DECISION DELEGATED TO HEAD OF PLANNING

Application No:	H08-0465-24	Applicant:	Mr Parker
Proposal:	Change of use from agricultural building to 2 residential dwellings		
Location:	G & M Tomlinson Farm Buildings Cheal Road Gosberton		
Terminal Date:	30th July 2024

Existing Site Layout Plan

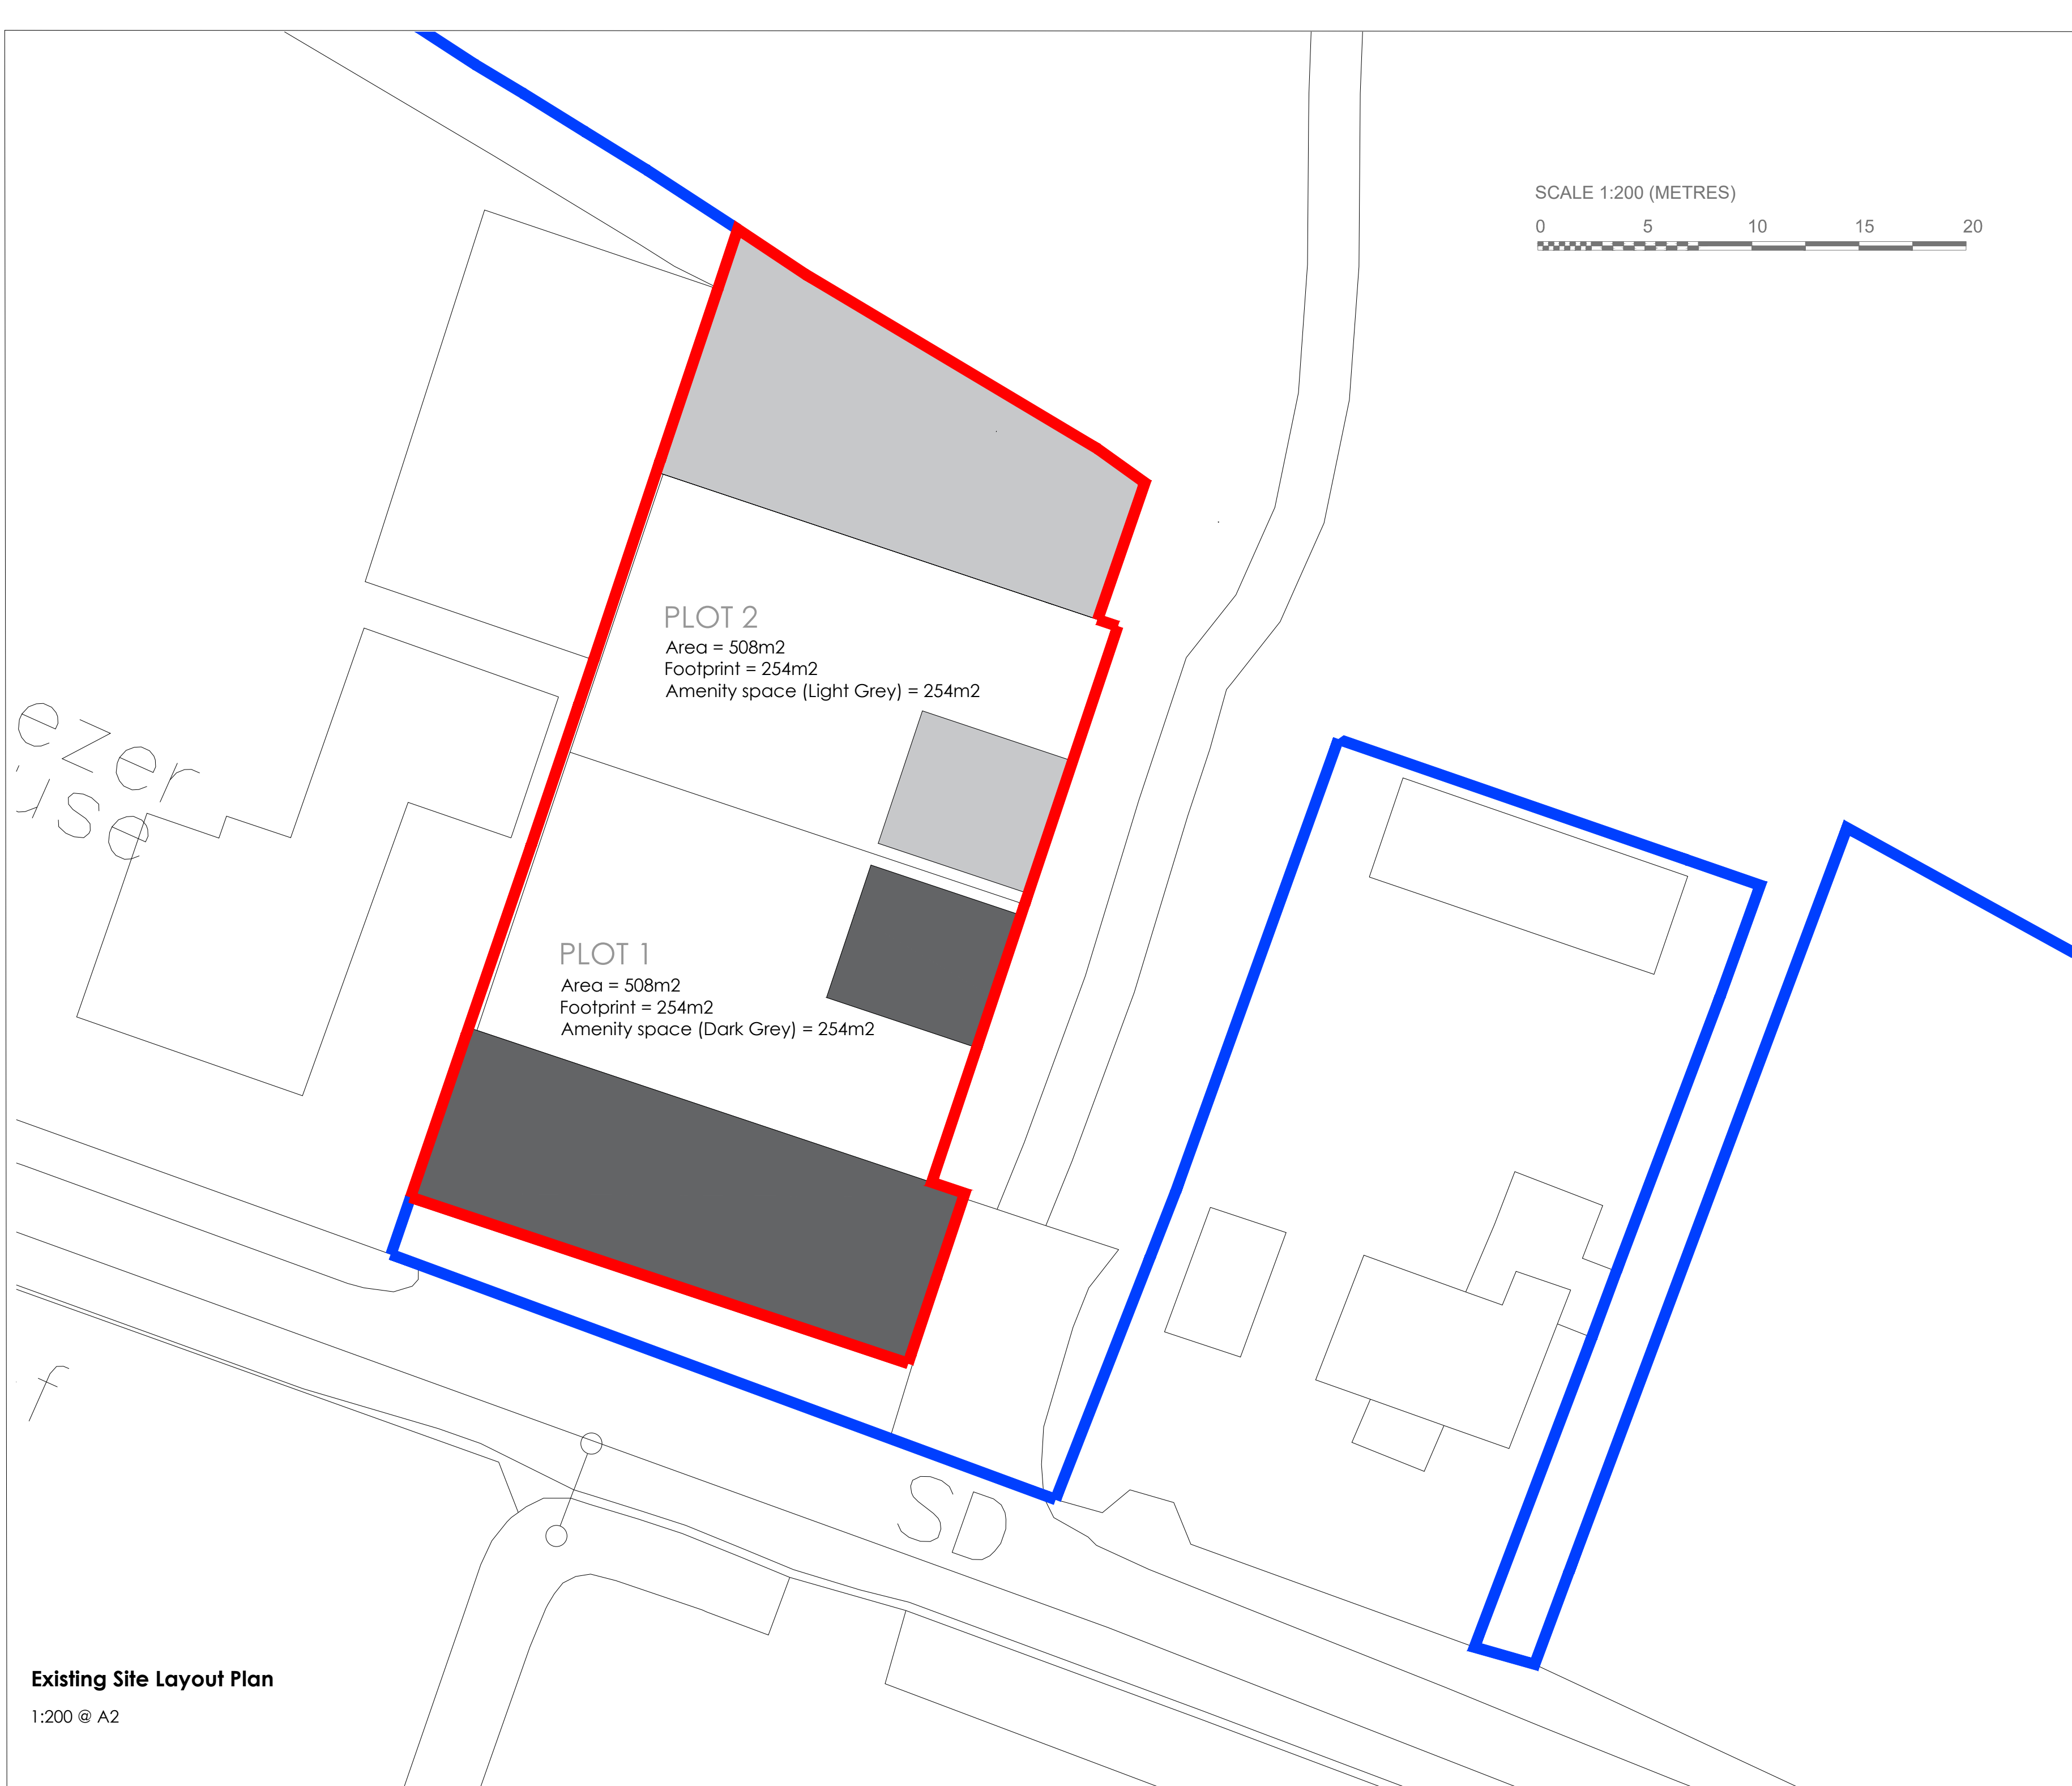
The proposed development affects Gosberton Public Footpath no.6. Unfortunately, this is a situation

where the legal alignment and the walked route on the ground are slightly different. In this instance, the legal alignment is affected by the boundary treatments on the northerly plot. This situation could be remedied by realigning the proposed hedge and post and rail fencing and relocating the bin storage area."

-To remedy the concerns raised by the Highway Authority re Gosberton Public Footpath no.6, an amendment was sought to realign the relevant border to ensure that no interference with the footpath would occur.
